ADJACENT LANDOWNER SUBMISSION OF COMMENTS FOR APRIL 18, 2024 HEARING
PROJECT FILE NUMBER SP 238, OVERLOOK AT HOMESTEAD
SUBMITTED BY ROGER AND JOANN LUND, TRUSTEES OF THE LUND FAMILY REVOCABLE
LIVING TRUST, OWNERS OF APEX RANCH ESTATES LOTS 15 AND 16
SUBMITTED APRIL 16, 2024

PRELIMINARY GRADING PLAN NORTH

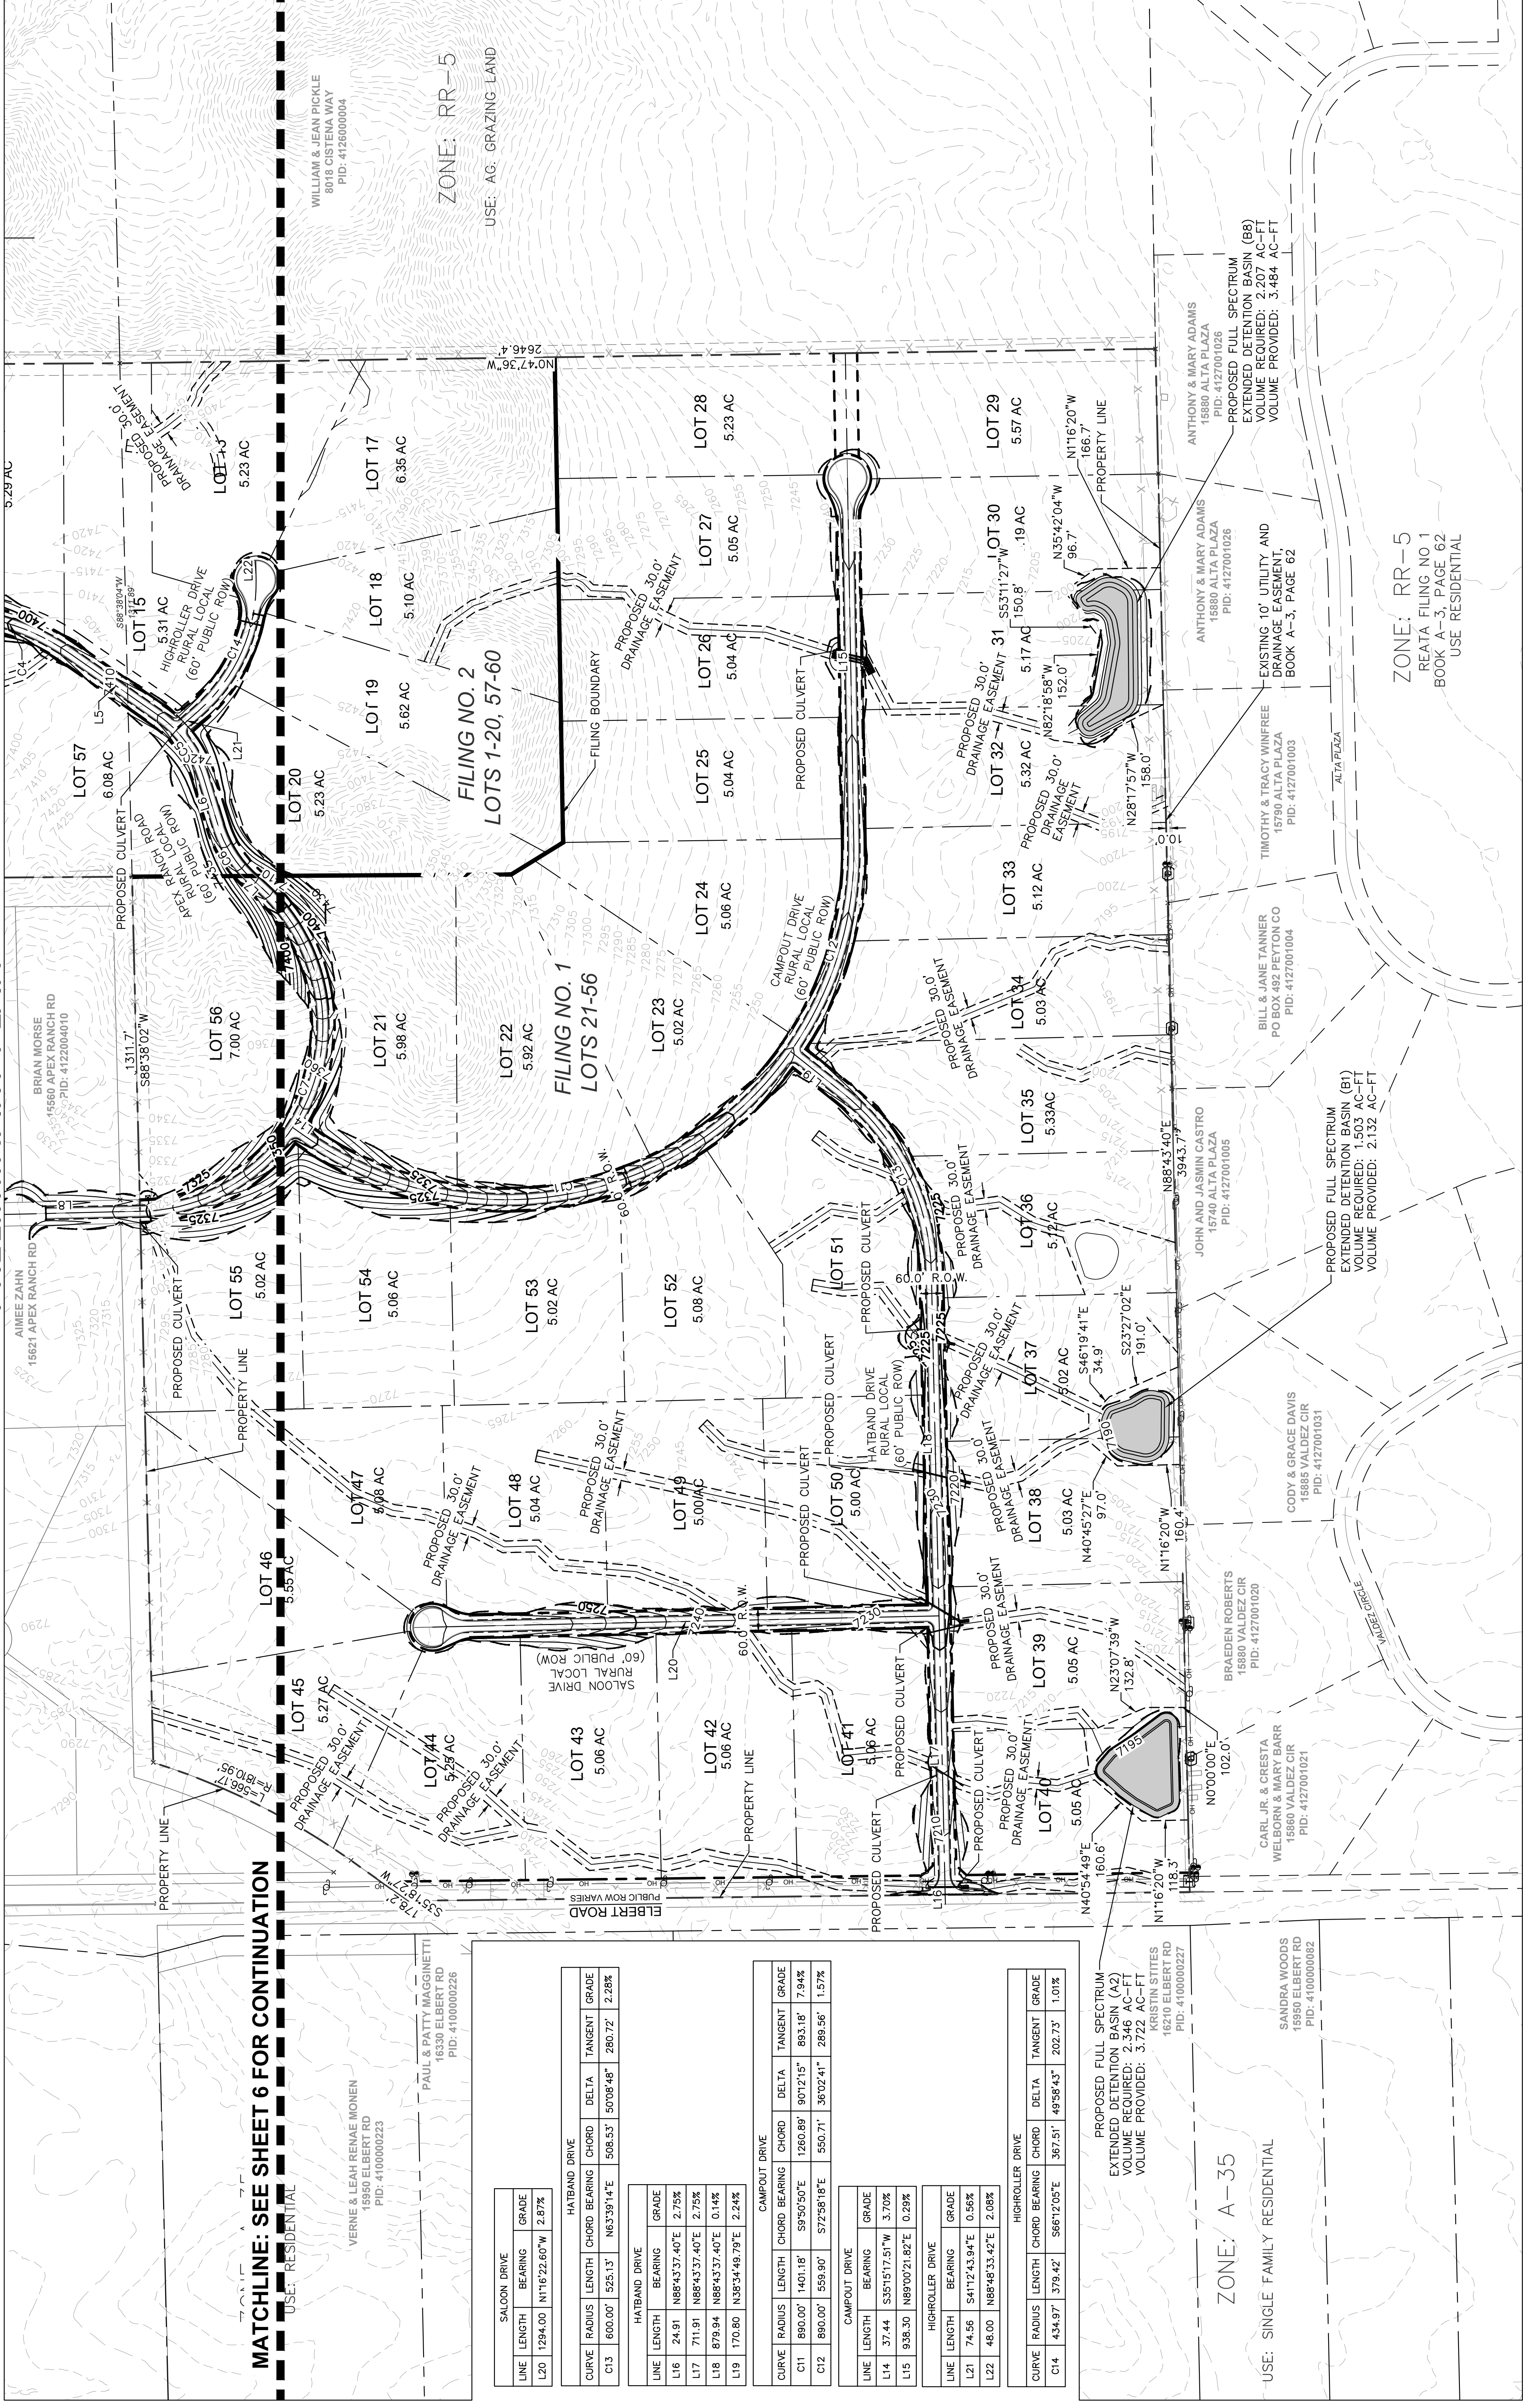
- 1) Our overriding concern is the adequacy of the proposed Stormwater Management Plan, especially as regards the location and adequacy of the detention pond sited between Lots 58 and 59 of Overlook. This issue was communicated to you in our November 8, 2023 letter emailed and hand-delivered to NES representatives at the neighborhood meeting of that date.

As stated in that letter, drainage from two major drainage easements on or abutting Lots 58 and 59 flows directly off of Overlook property and into a deep ravine between Lots 16 and 17 in Apex Ranch Estates, through culverts under Apex Ranch Road and Fletcherville Lane, into a detention pond near that intersection, then along Fletcherville Lane until exiting the subdivision boundary to the north. Previous storms in early summer 2023 have overwhelmed this course of flow, and any uncontrolled additional runoff from development above us (i.e., Overlook) has the very real potential to cause damage to both individually-owned and HOA-owned properties in Apex Ranch Estates.

Interestingly, a review of the plat shows that of the six detention ponds proposed for Overlook, five of them are located to control flows immediately before leaving the property line from Overlook onto adjacent properties; the only one that does not do so, and in my opinion could be re-engineered to offer a higher level of protection to my and Apex Ranch Estates' property, is the one I am questioning.
